Dionne Tiny House, BOA-18-002

Please accept the following comments from El Paso County Public Health regarding the project referenced above:

WELL RADIUS  
35.2  
SITE PLAN

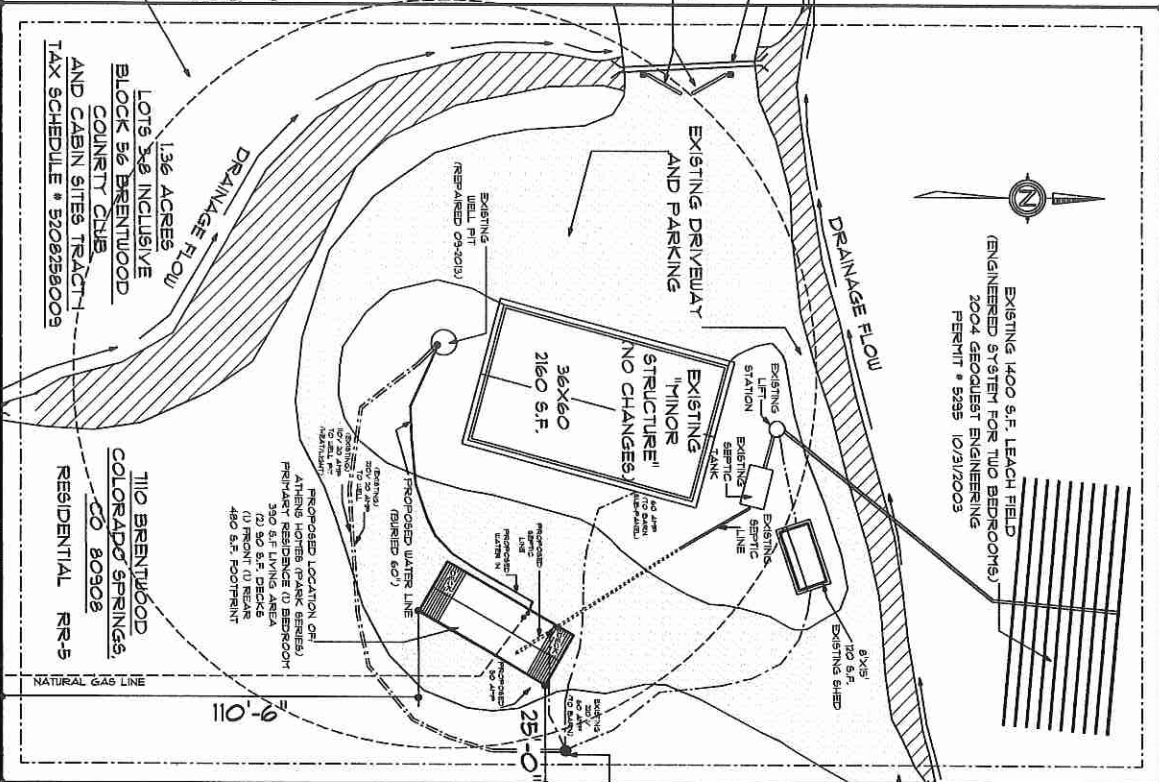
- The entire soil treatment area (primary and secondary sites) must be protected from vehicular traffic. It is recommended that the area be protected with fencing or landscaping to prevent accidental damage by construction equipment.

- A Minor Repair OWTS Permit is required to connect the new house to the existing PVC line connected to the septic tank. Please contact El Paso County Public Health to inspect the new building sewer line connection prior to back-filling.
